Application No: EP/51/20/HH
Site Address: 1 Lashmar Road East Preston BN16 1ES
Description of works: 1.8m wall to front including removal of bushes.

Thank you for your internet representation made on 11th June 2020 which has been recorded as an objection with the comments as follows:

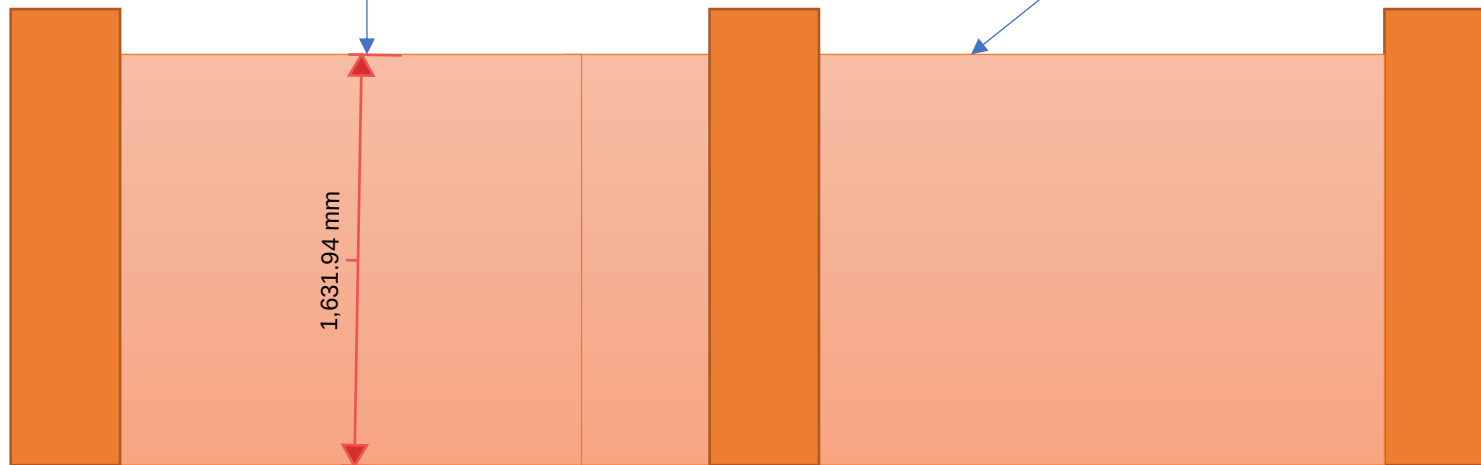
This application proposes building a wall six feet high along the street frontage of 1 Lashmar Road.

The East Preston Neighbourhood Plan states that, for Character Area Four in which this development is located

"The priority is to preserve the the present street scene which features low walls and open front gardens. The construction of higher front garden walls should be resisted".

Policy 5 (I) of the EPNP states that high front garden walls or fences should be avoided.

This application therefore directly conflicts with the policies of the EPNP' It should be refused.
